GREATHOUSE, Kyle
12320 Gull Lane
Peyton, CO 80831-7781

Parcel #4319002024

Lot 9 Blk 1 Falcon Hills Sub No 4

Zoning: RR-5

Proposed
120'x50'
Garage with
10'x60 porch

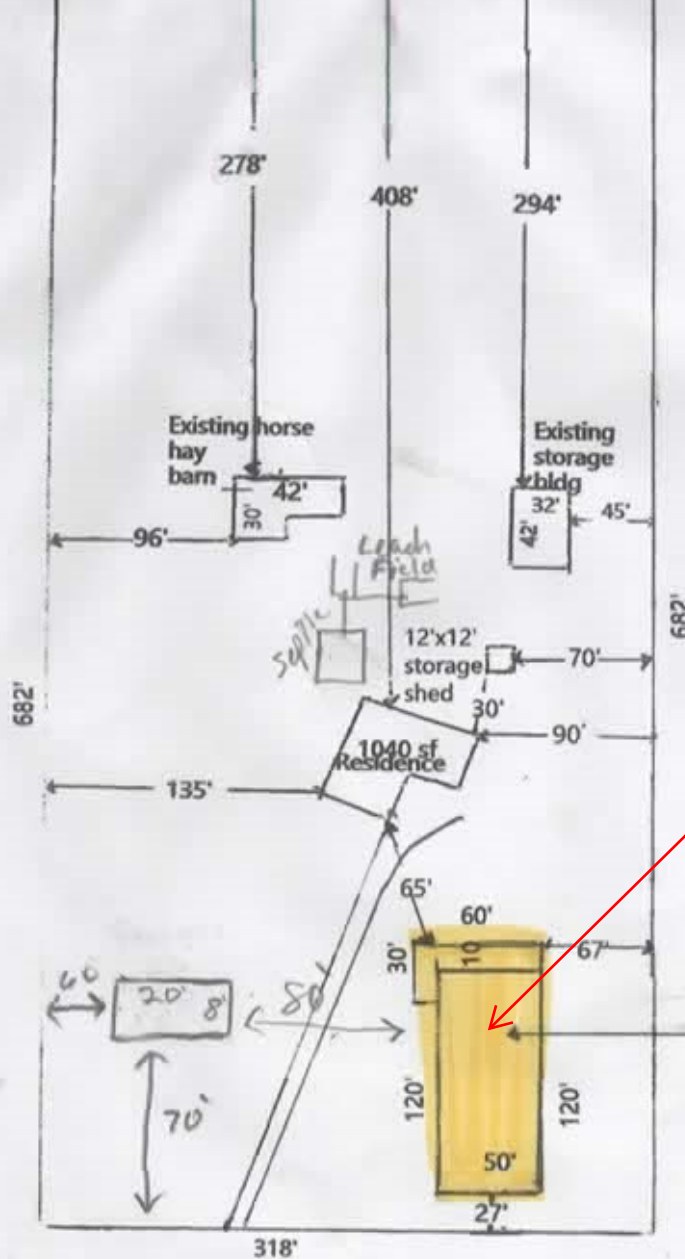
Per the subdivision final plat, please show a 10' public utility and drainage easement within the side and rear property lines.

Please depict the location of the well

Please indicate the existing lot coverage percentage and proposed lot coverage percentage if the proposed structure is approved.

Please make these match the plat which created this property

Please indicate what this structure is used for

Please include note:
60' Public Local ROW

Please depict the traffic circulation on site

Please label as property/ROW if that is what this is.

A driveway access permit is not on file for the existing driveway onto Gull Lane. This application can be self initiated in EDARP and instructions have been uploaded into EDARP as a separate comment regarding how to apply for a driveway access permit. An 18" driveway culvert is required as a part of a rural driveway. Please submit an application prior to the BOA hearing.

Please depict on the site plan if any new driveway access to Gull Lane is proposed. If additional access is proposed, please include this on this site plan and on your driveway access permit application.
